Your Ref: OWPC18684
Our Ref: BR/229/17/PL 11-08-2017
Please ask for:
Mr S Davis

Erection of 3 No. dwellings, 1 No. detached garage, parking & alterations to existing access & driveway (resubmission following BR/200/16/PL).

Land to rear of 41 - 47 Pevensey Road Bognor Regis

Thank you for your internet representation made on 7th June 2018 which has been recorded as '**an objection**' with the comments as follows:

Proposed Elevations

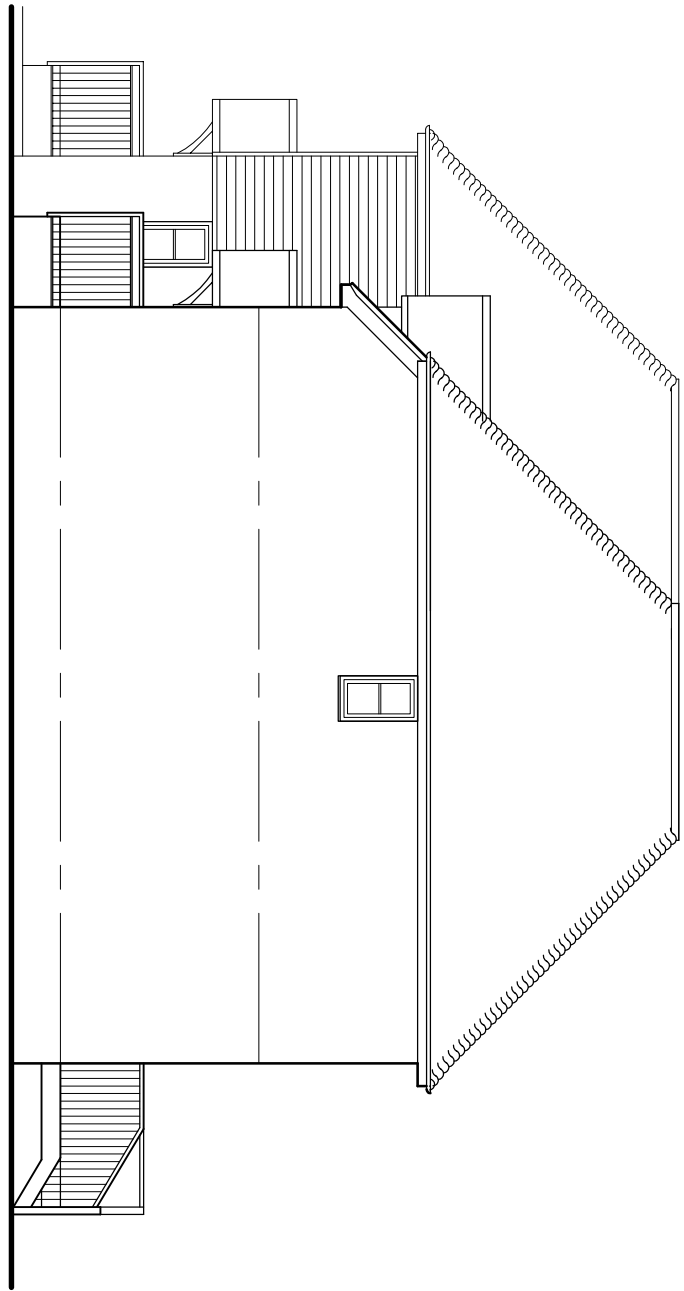
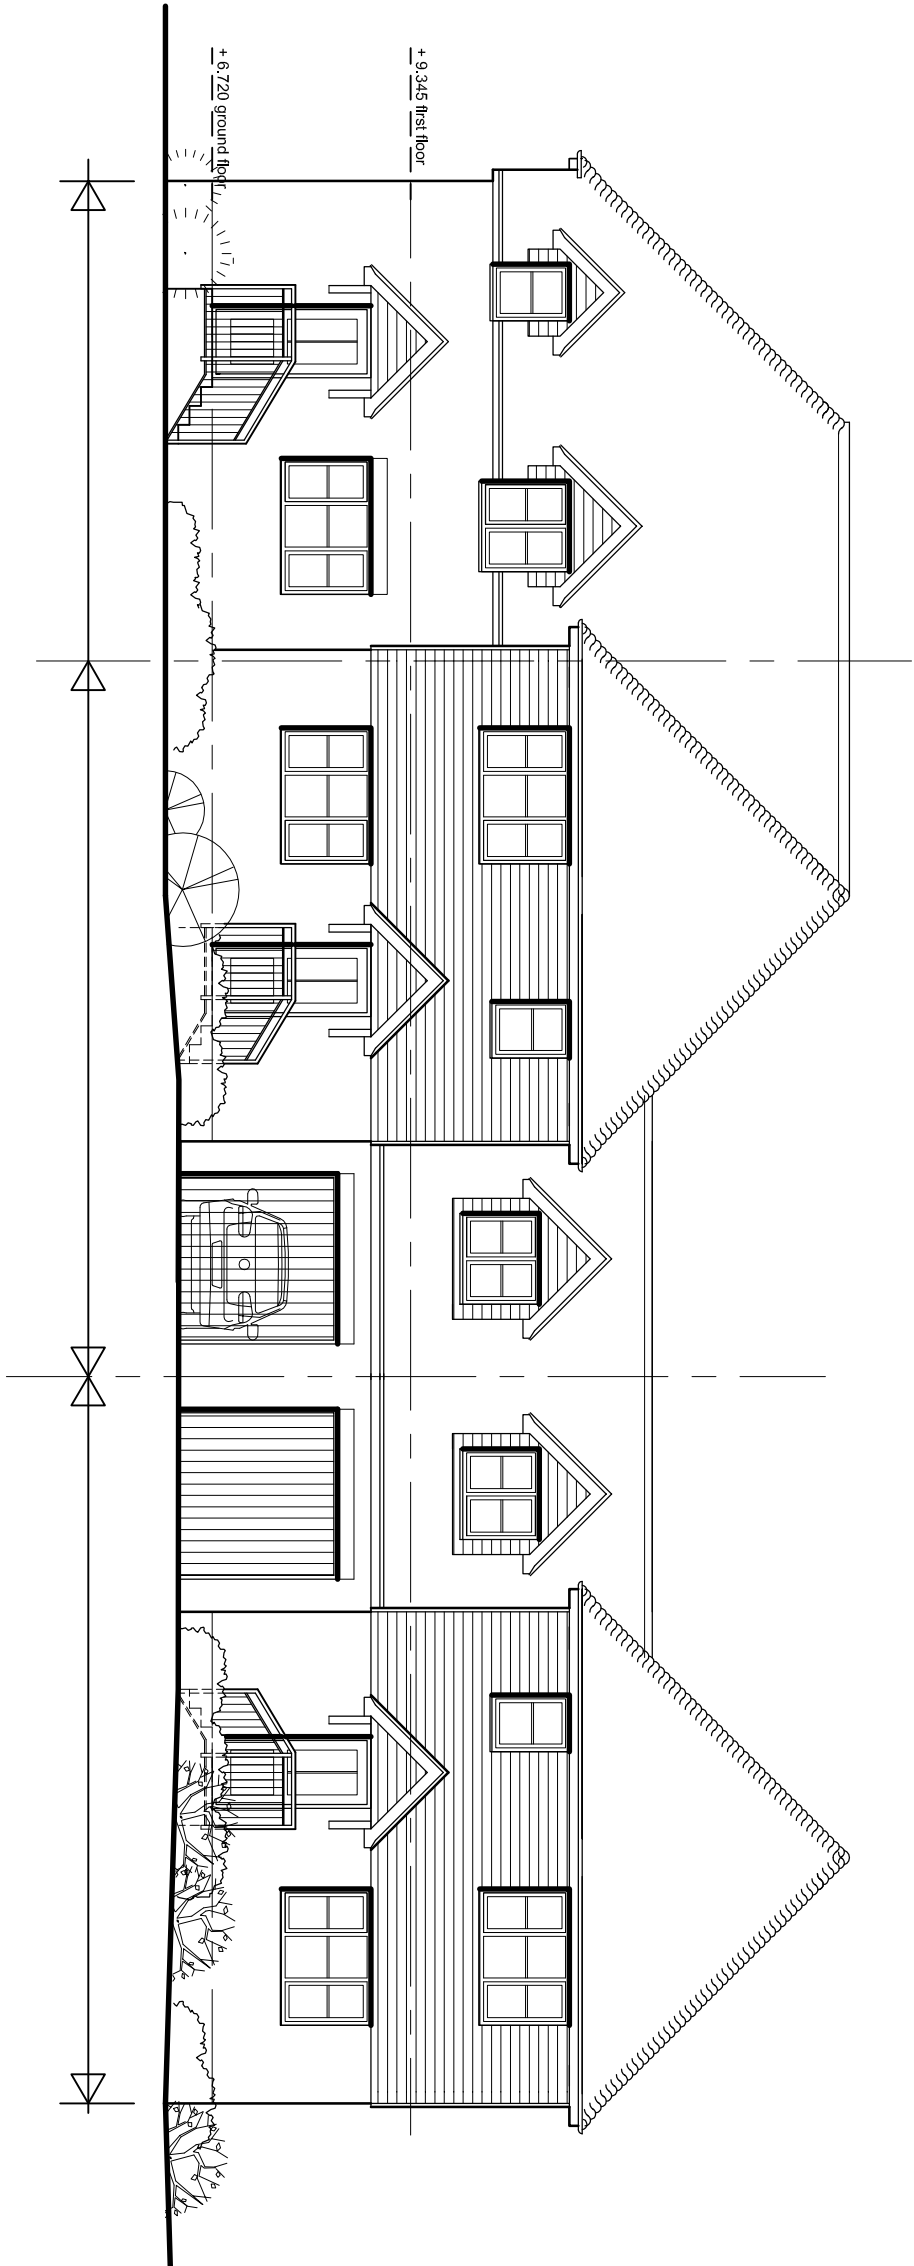
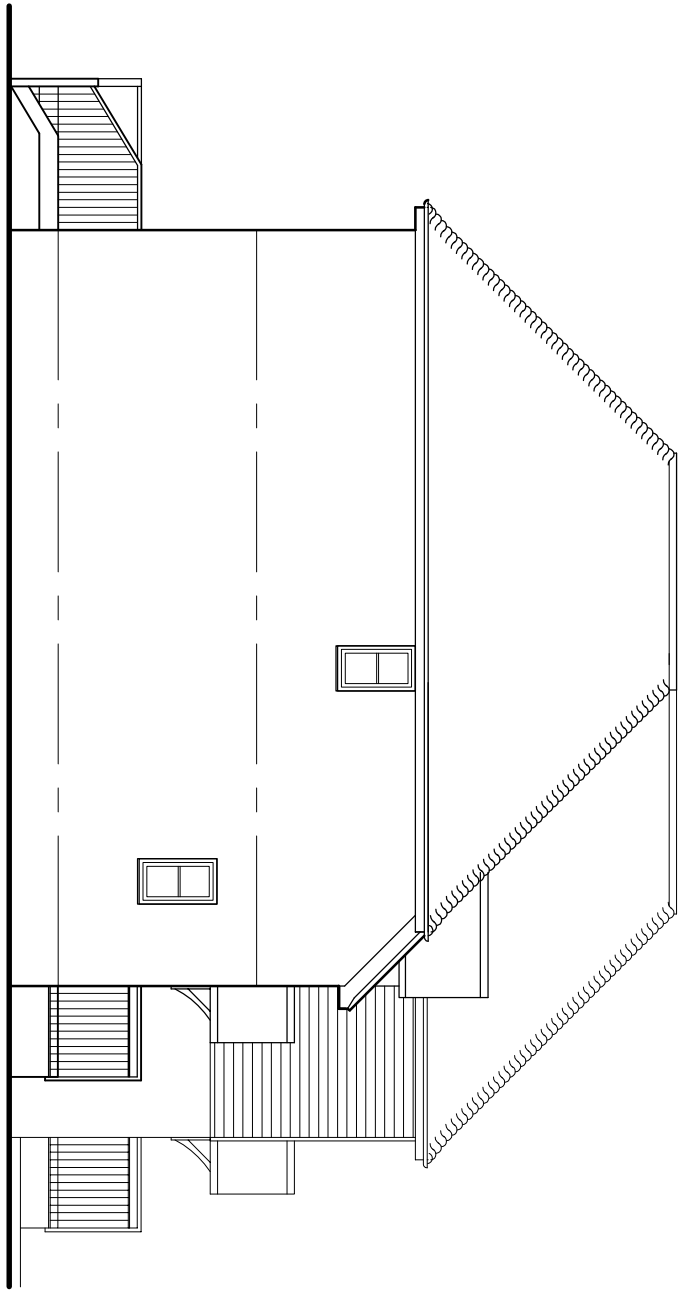
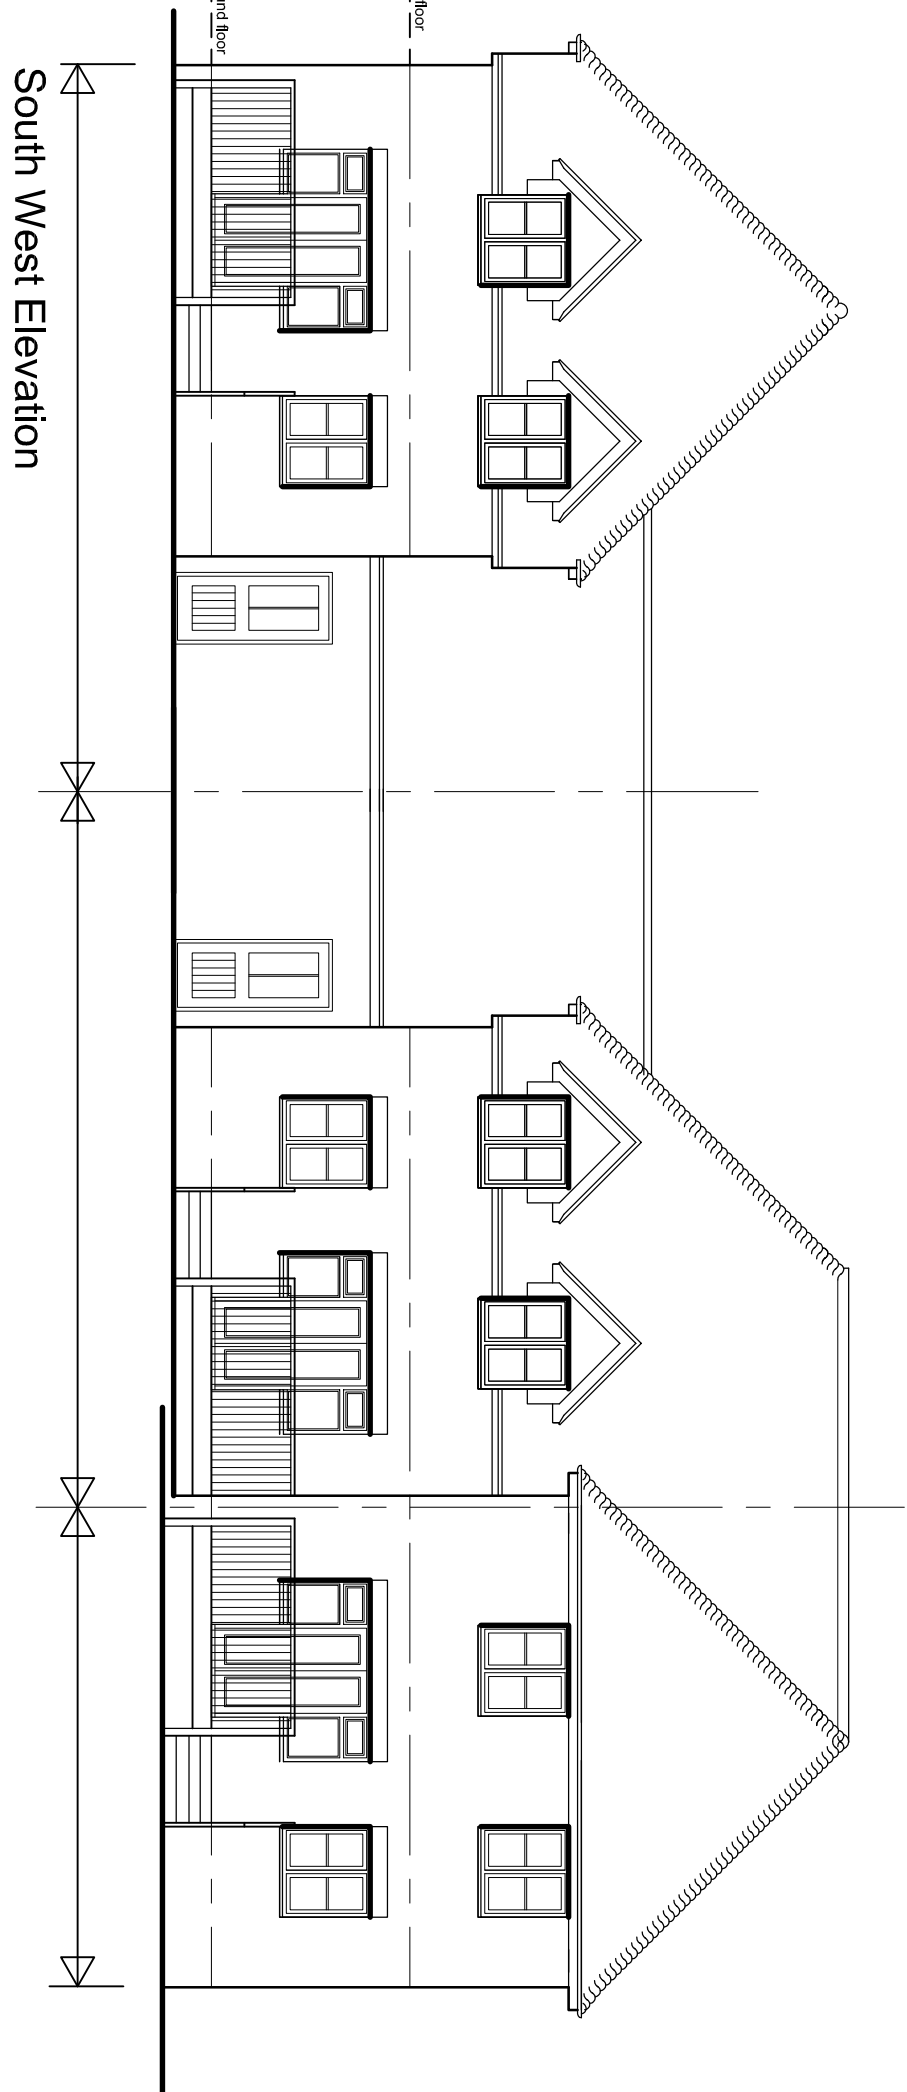
The proposed new dwellings will be higher than our house and their windows and doors on a higher level due to the flooding issues this site has, we would feel overlooked due to the number of normal glazed windows the houses would have, also the raised decking would look into our house.
